City of Ryde Submission

**Greater Parramatta and Olympic Peninsula Water
Resource Recovery Facility by Sydney Water
SSI-74258485**

**Council File reference: COR2024/135/2
Submission Date: 10 March 2026**

Figure 8-1 Project impact area including indicative construction compounds

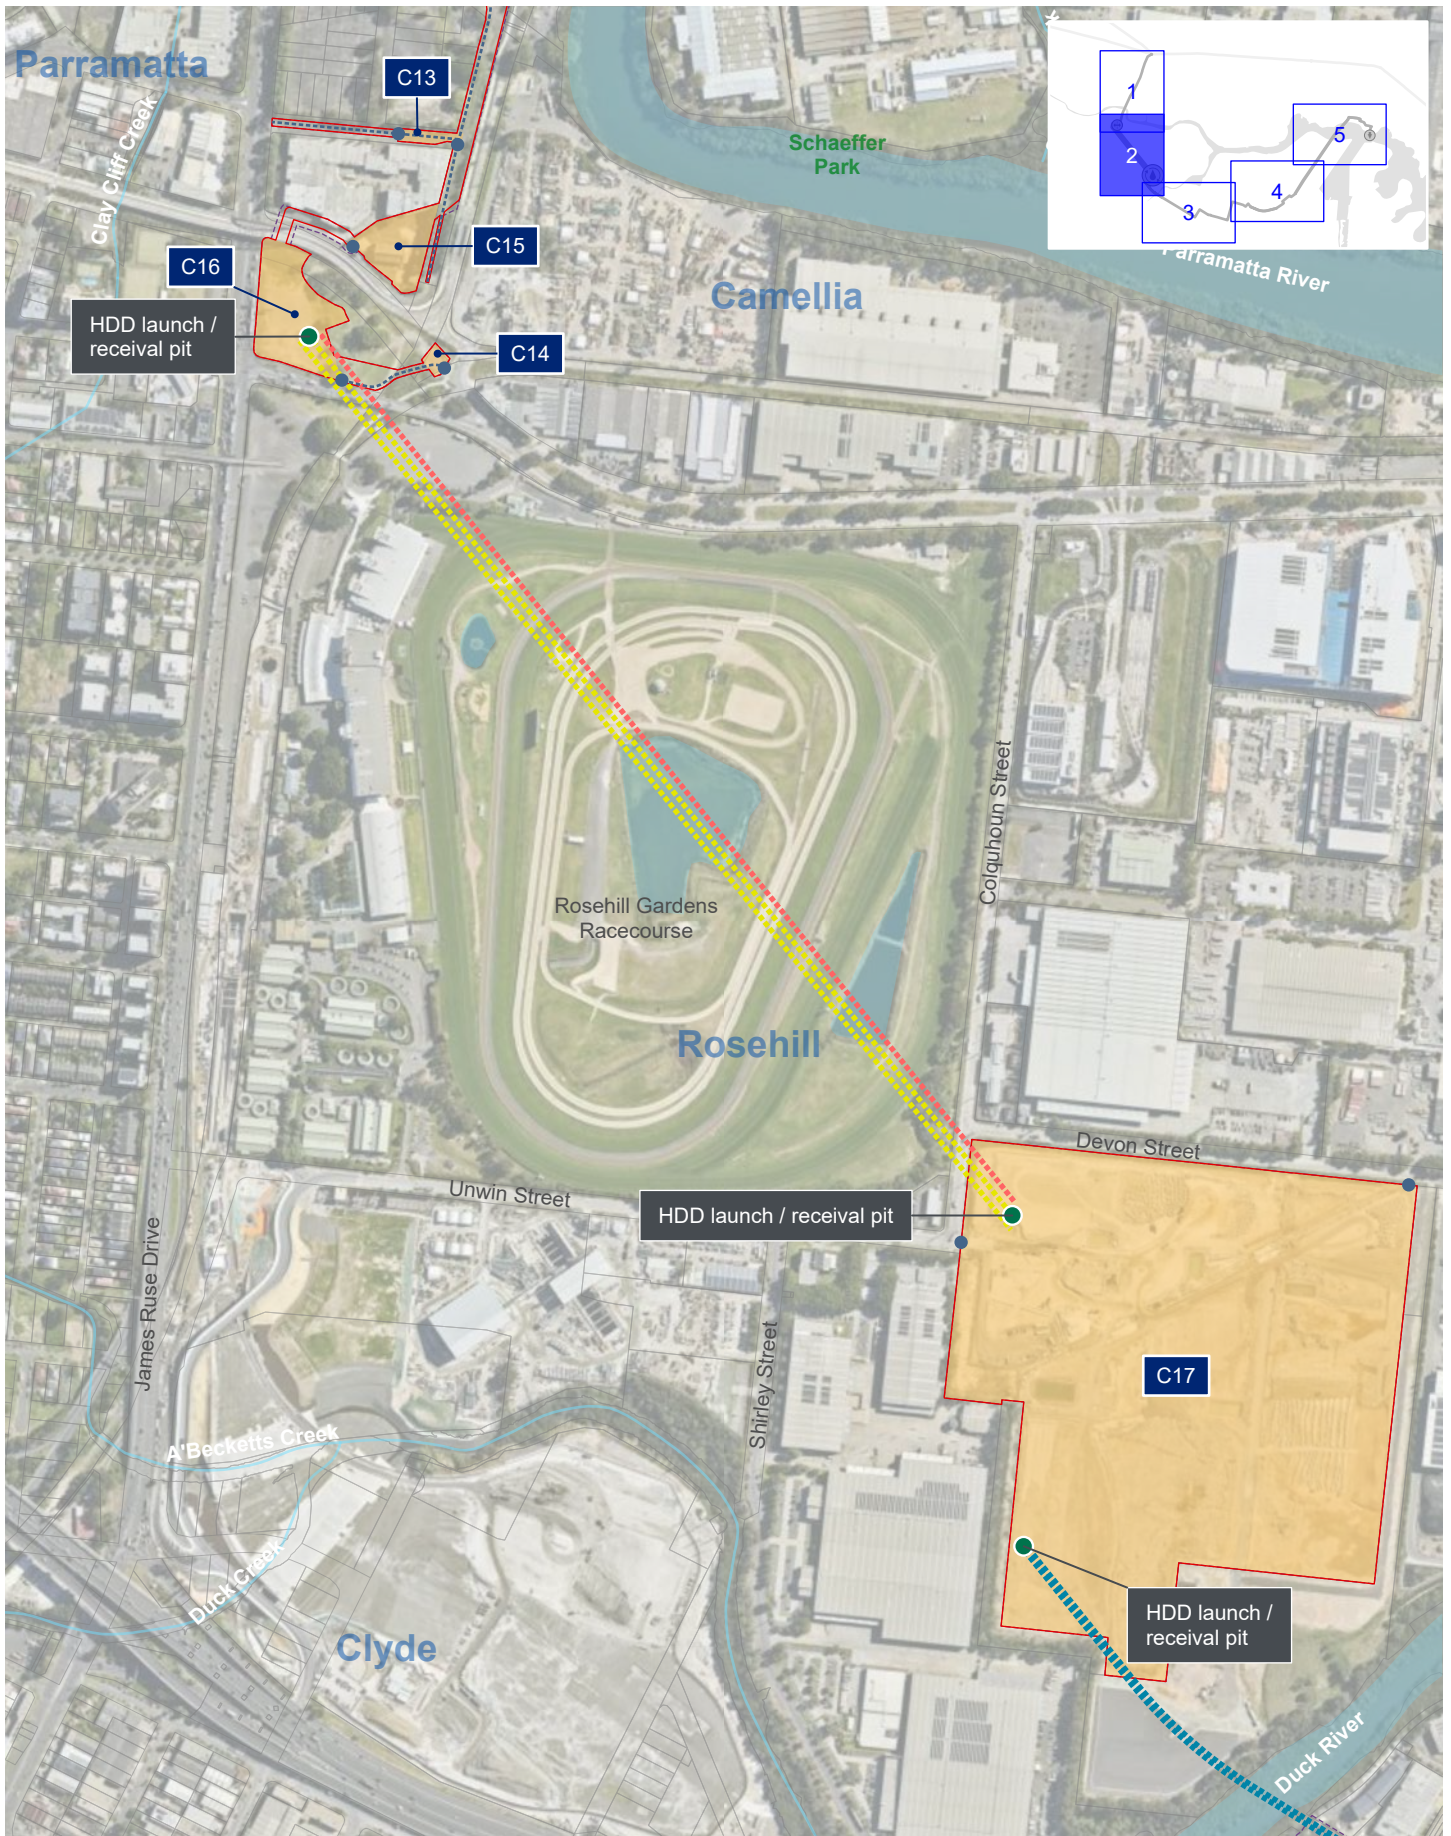
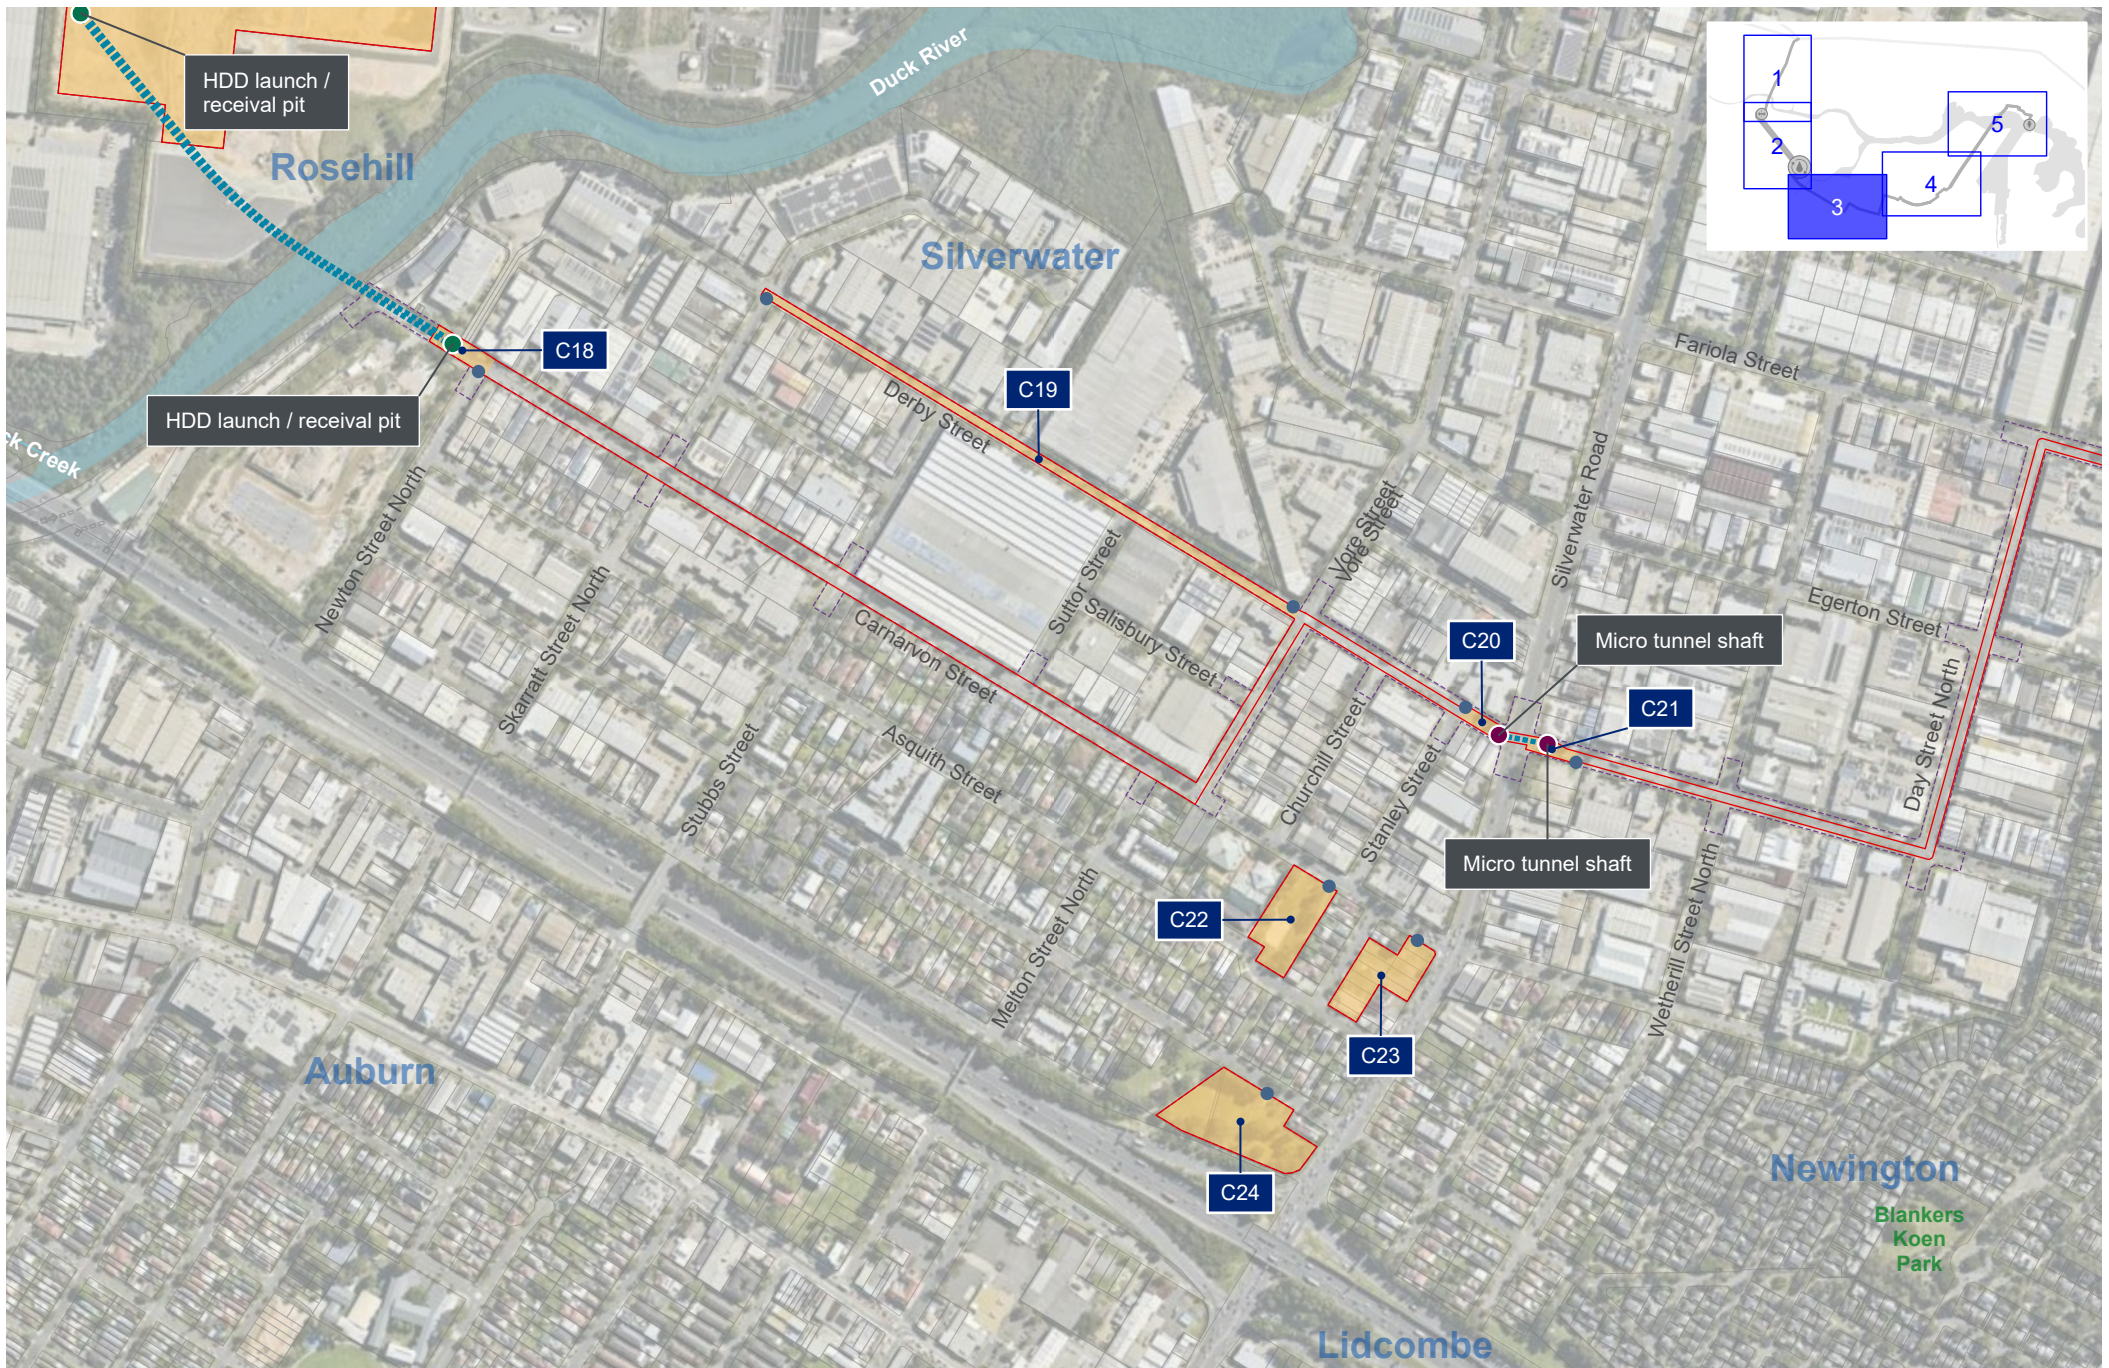
- a. The Application provides conceptual information with demarcation shown on aerial maps, which lacks cadastre level details that is otherwise required with any Development Application, to inform precise location of works and related impacted areas. It is impossible to ascertain details of the works and proximity to critical service areas based on the broad concept shown in the EIS. Given the lack of details, the applicant should be required to provide additional Civil Drawing with details of the proposal comprising technical, spatial representations of site details, exact location of pipes, boring and trenching, depth, width and proximity from infrastructure such as existing roads, paths, drainage, playground, driveways and so on. The plans should include plan views, cross-sections, and in-ground utility layouts to ensure project accuracy, safety, and adherence to standards.

The current plans are inadequate as shown below:

Figure 3-6e Indicative river release pipeline alignment

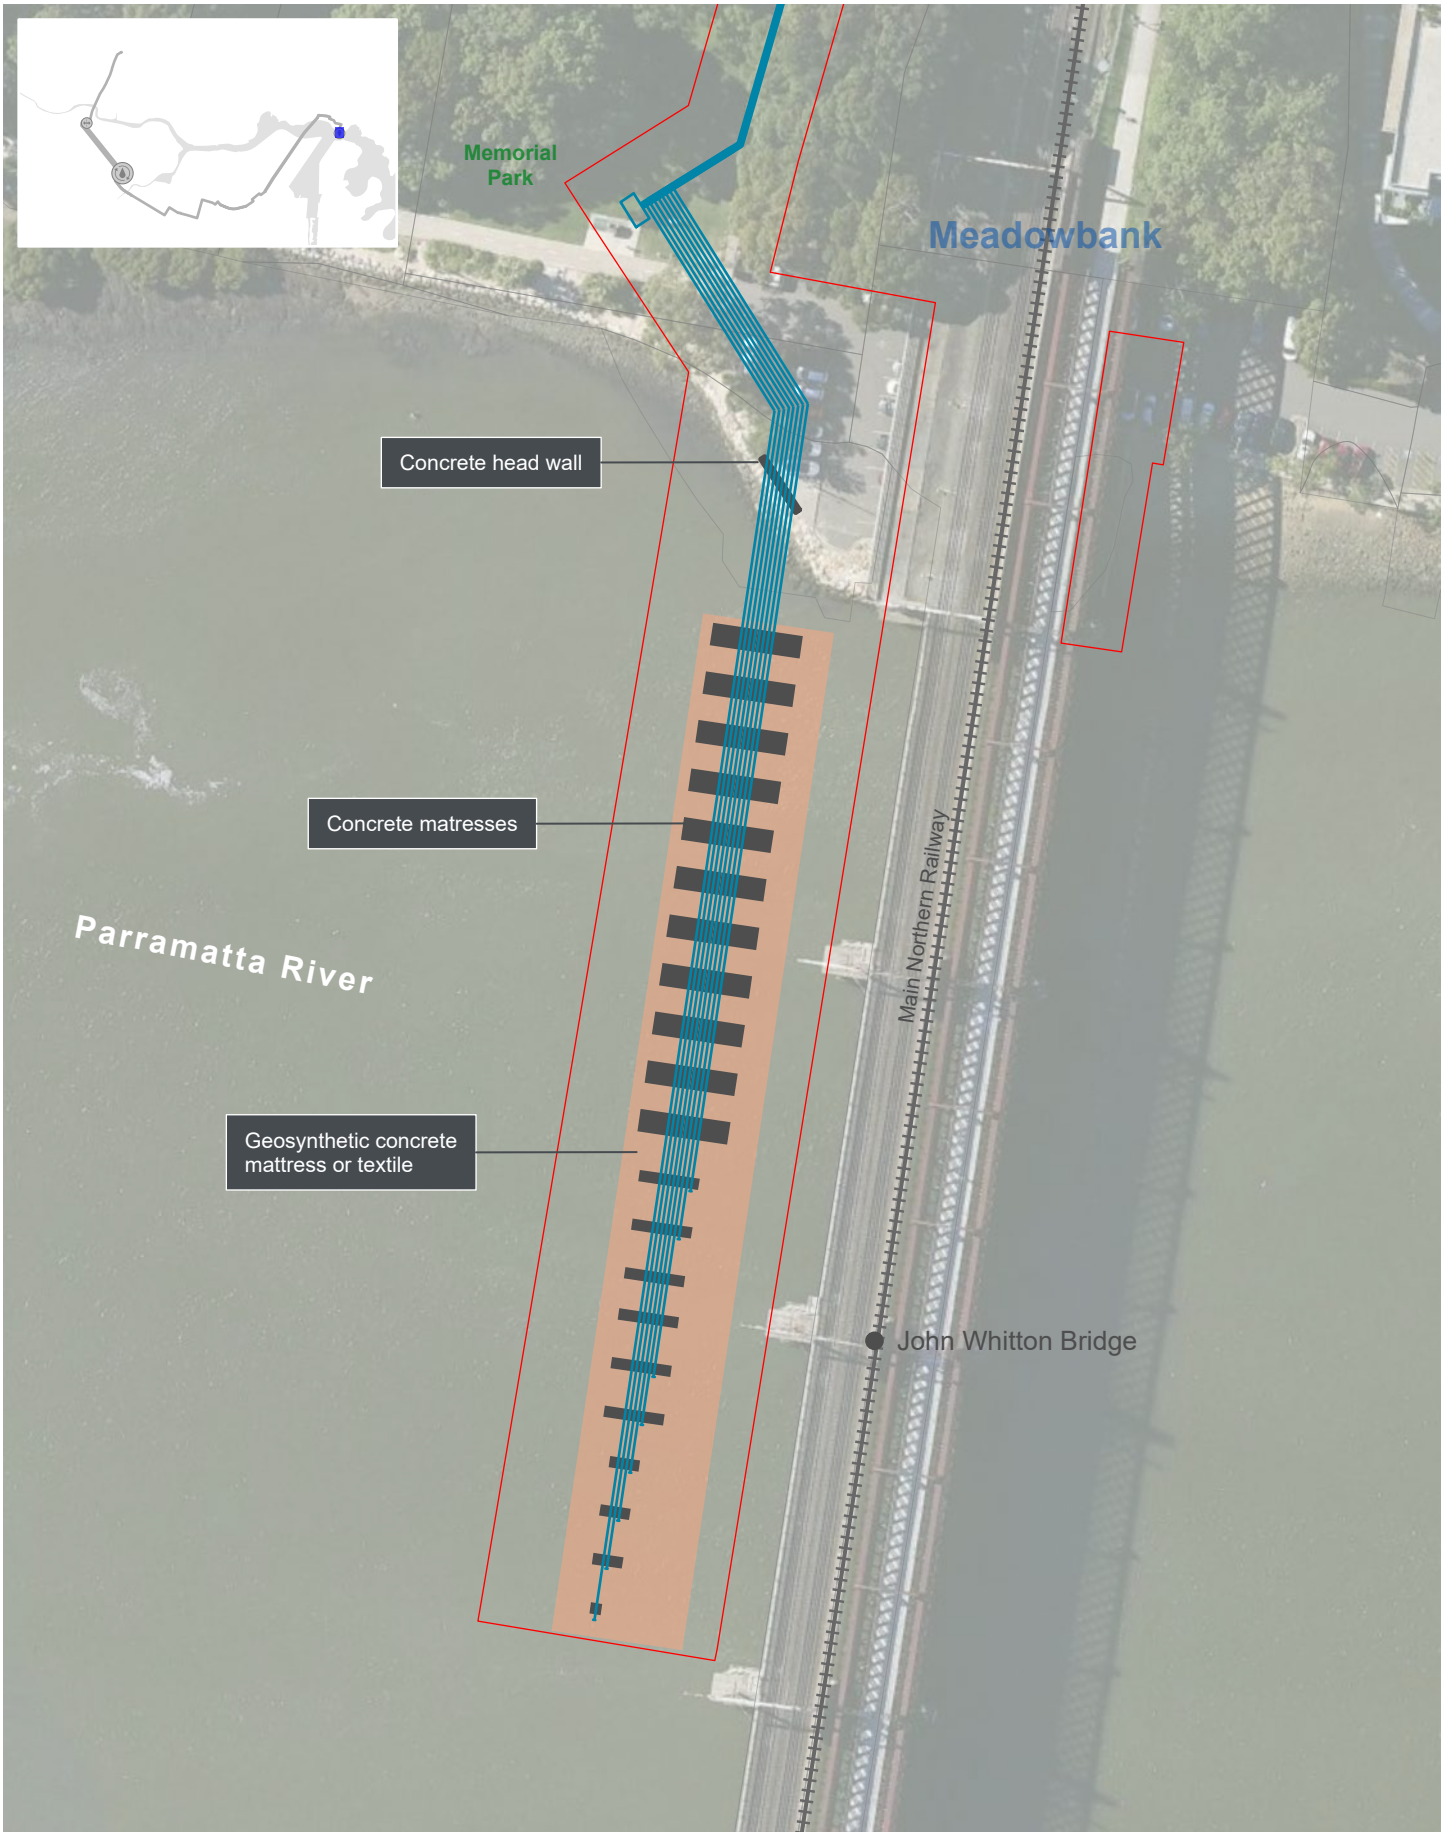
- b. It is not clear from the Concept Plan and details annotated on the plan/legend as to where exactly the trenching is proposed adjoining the Meadowbank Park and the HDD launch area. Further, the plans notate all areas as “indicative” areas, for example, “indicative construction compound” next to Meadowbank Park, it shows “indicative compound access. All areas in Meadowbank are shown in red outline which means all piping will be trenching. It is not clear if this will be open trench or what is meant by this methodology of laying pipes. The application states that “Sydney Water would use trenchless methods for construction where possible to avoid unacceptable disruptions to main roads”. Given that this method will not be employed for works in Ryde Council area, does this mean there will be severe impact to the open space, parks, roads and near the bridge. There is contradictory information provided on the summary sheet which indicates that “To address this, concern, a deep horizontal directional drill would be used to travel under Hill Road to Meadowbank Park”. Open trenching may be faster to lay pipes, but this may

Council seeks clarification on where and what the method of pipe installation is proposed in each location within the Meadowbank area and if trenching is the only option, how would impact on the Park and associated infrastructure and its use.
